# **APPLICANT'S RESPONSES TO RELEVANT REPRESENTATIONS AND ADDITIONAL SUBMISSIONS**

## **Drax Bioenergy with Carbon Capture and Storage**

**Document Reference Number: 8.3**

**PINS Reference: EN010120**

DRAWING NUMBER
EN010120-PA-ES-6.2.18.1-Sheet5

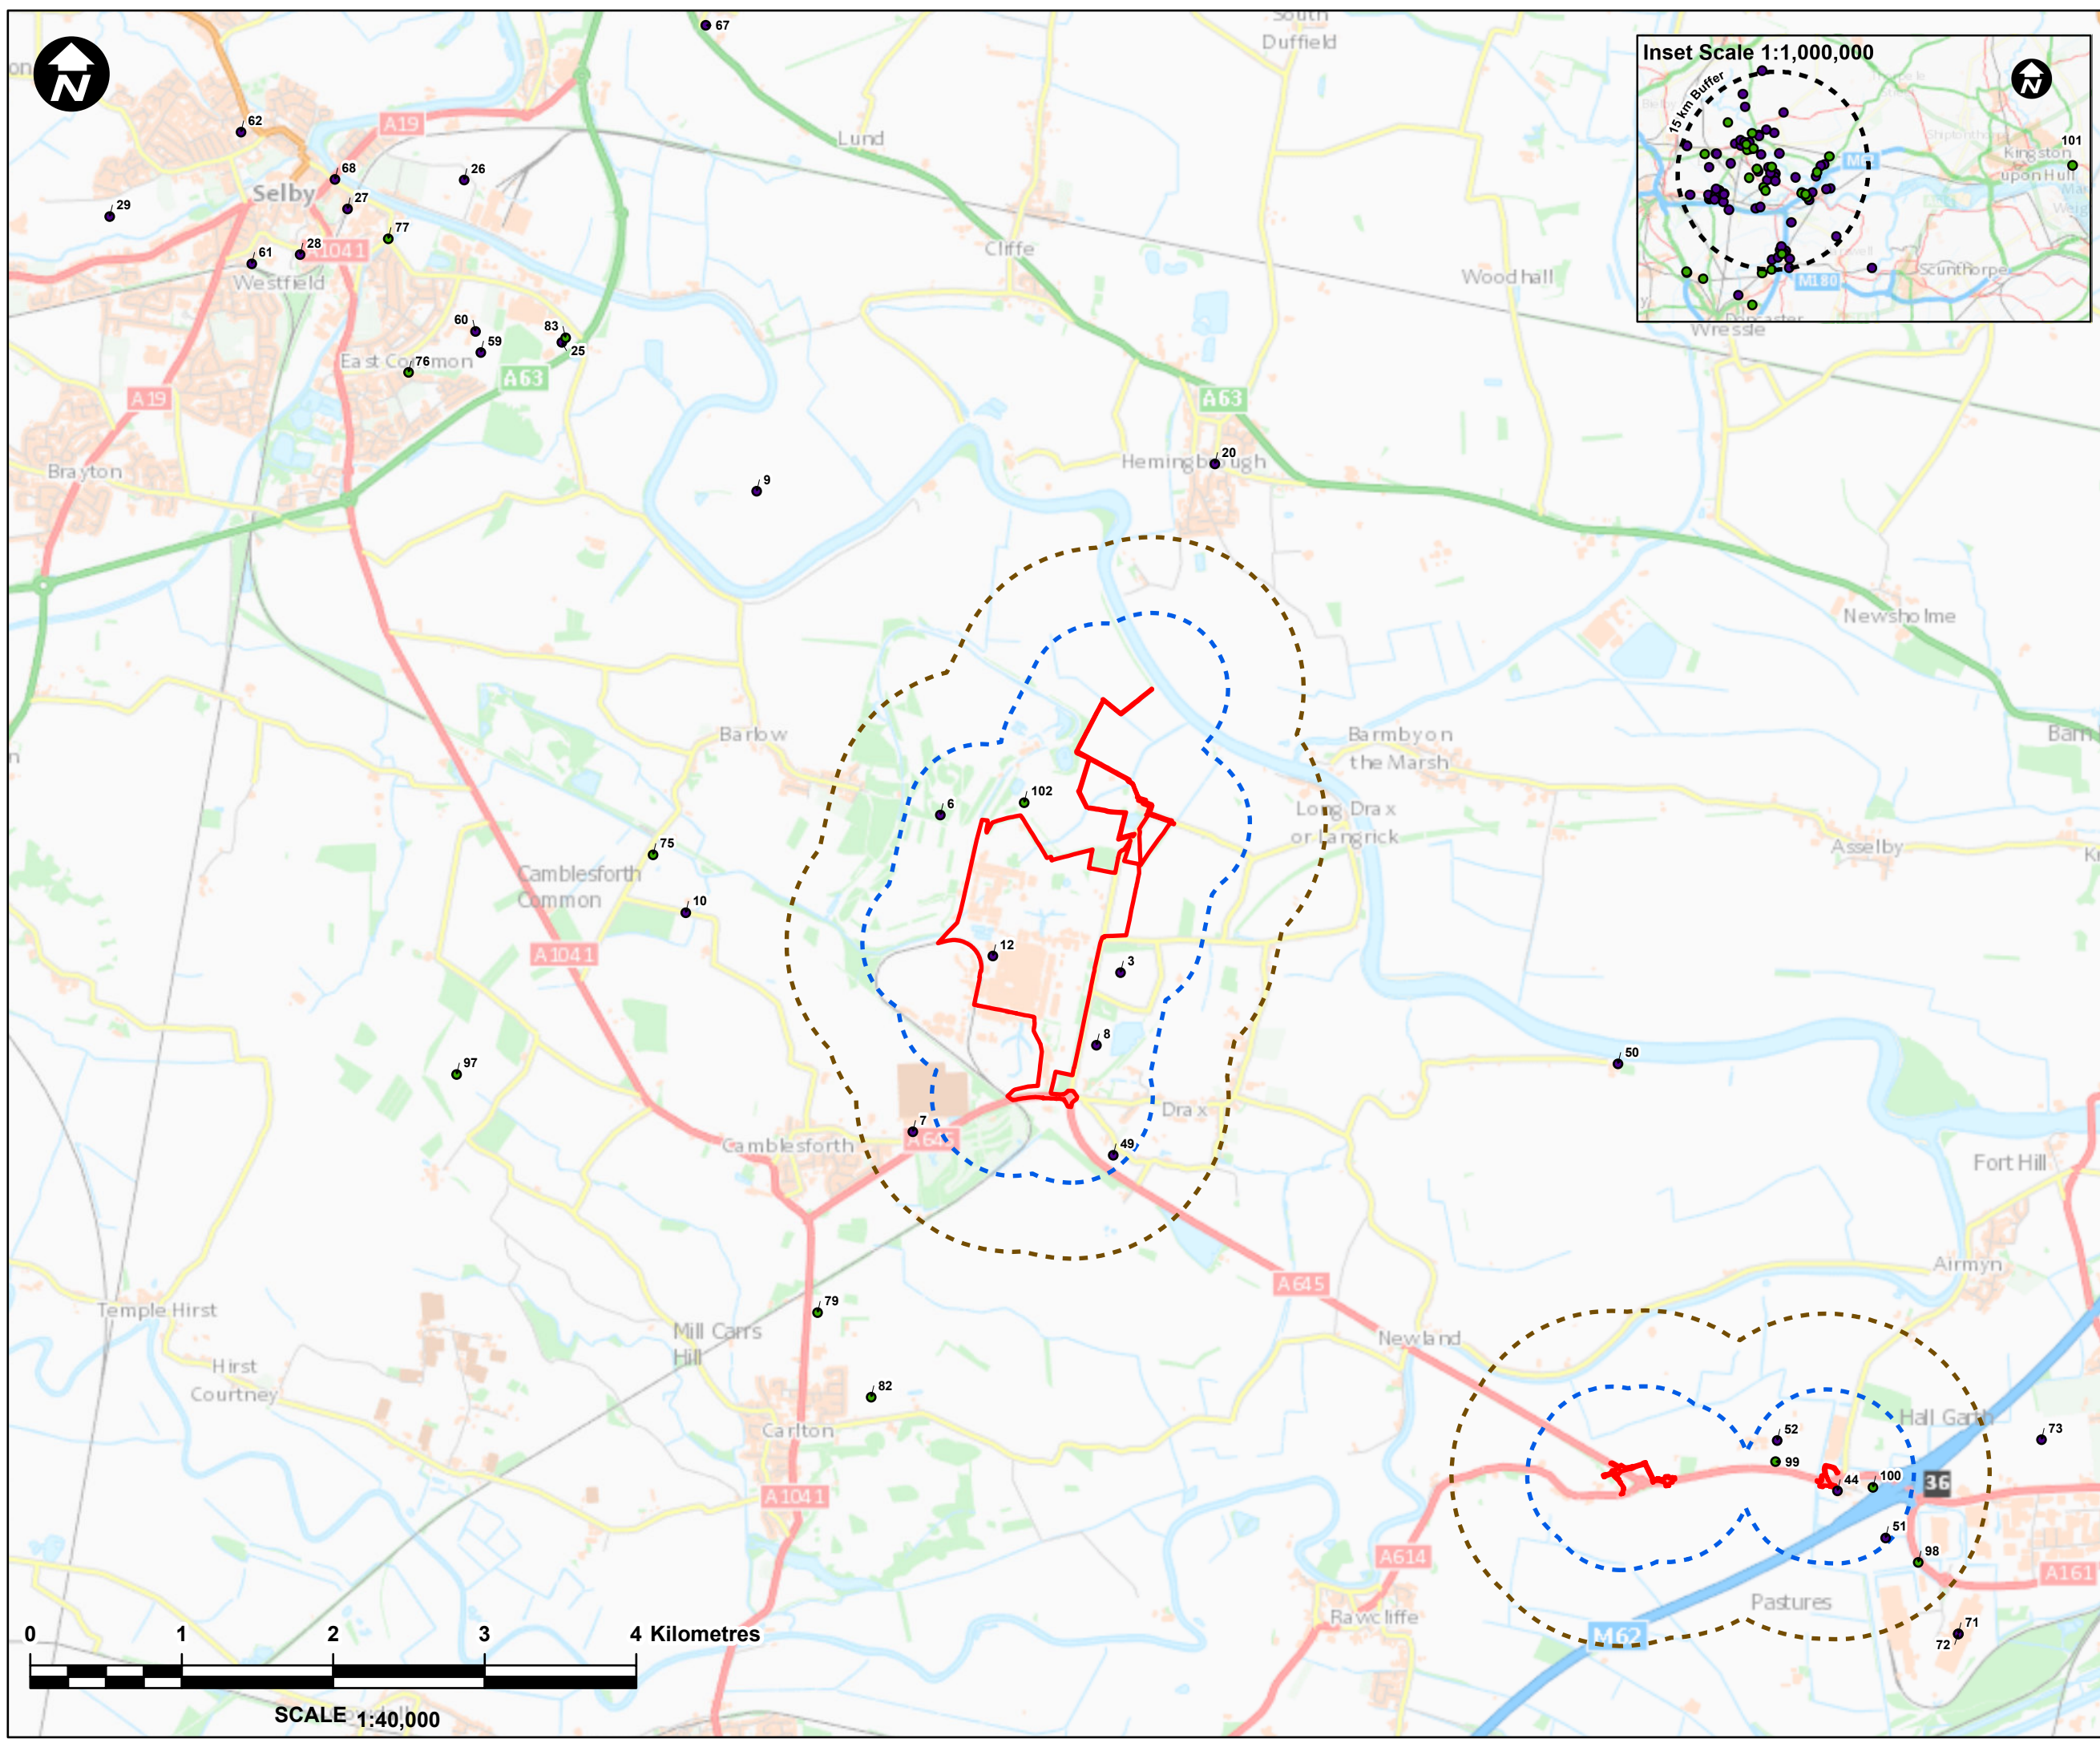
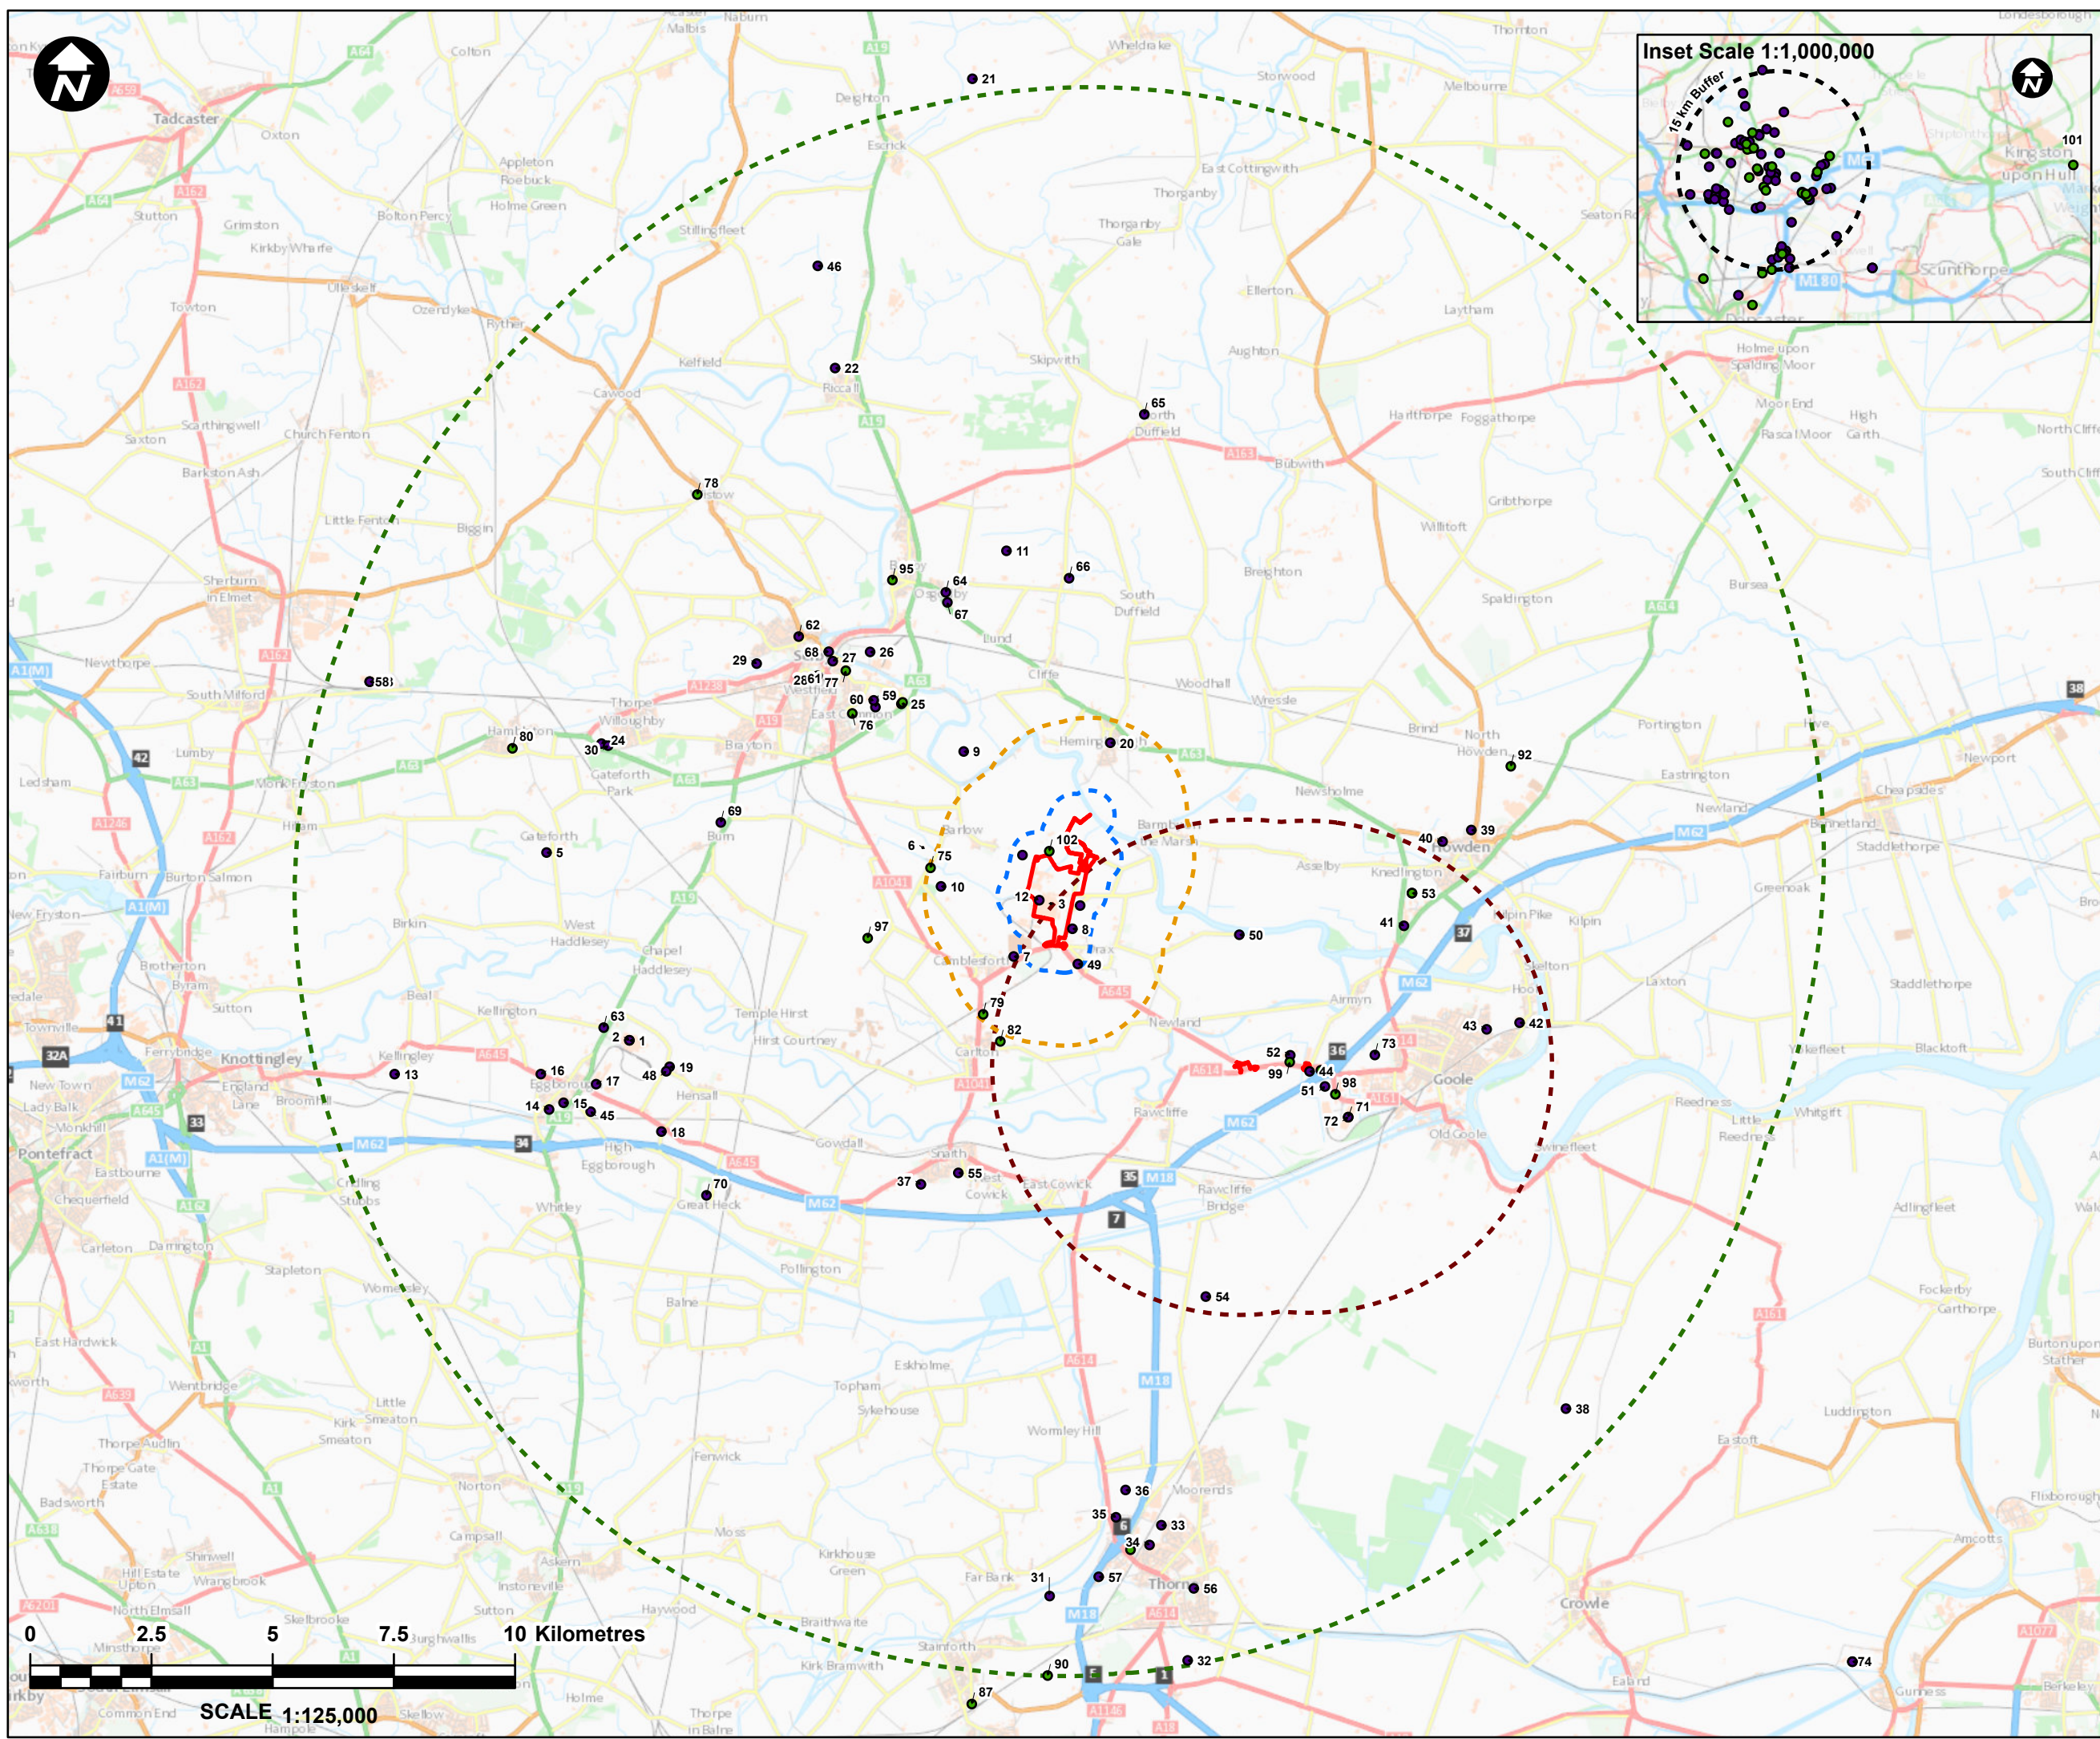
Response Ref.	Relevant Representation Comment	Applicant's Response
2.12. Cumulative	It has been noted that 6.3.18.2 Environmental Statement - Volume 3 - Appendix 18.2 'Short List of Other Developments' only contains 46 schemes, while the Environmental Statement refers to 76 schemes. It is understood that the applicant is aware of this issue and is looking to issue a corrected version for consideration.	This comment is noted and it is confirmed that the formatting error has been amended and a new version was issued to NYCC/SDC and other consultees on 1 September 2022. The updated document was reissued to PINS on 7 October 2022 (AS-013).
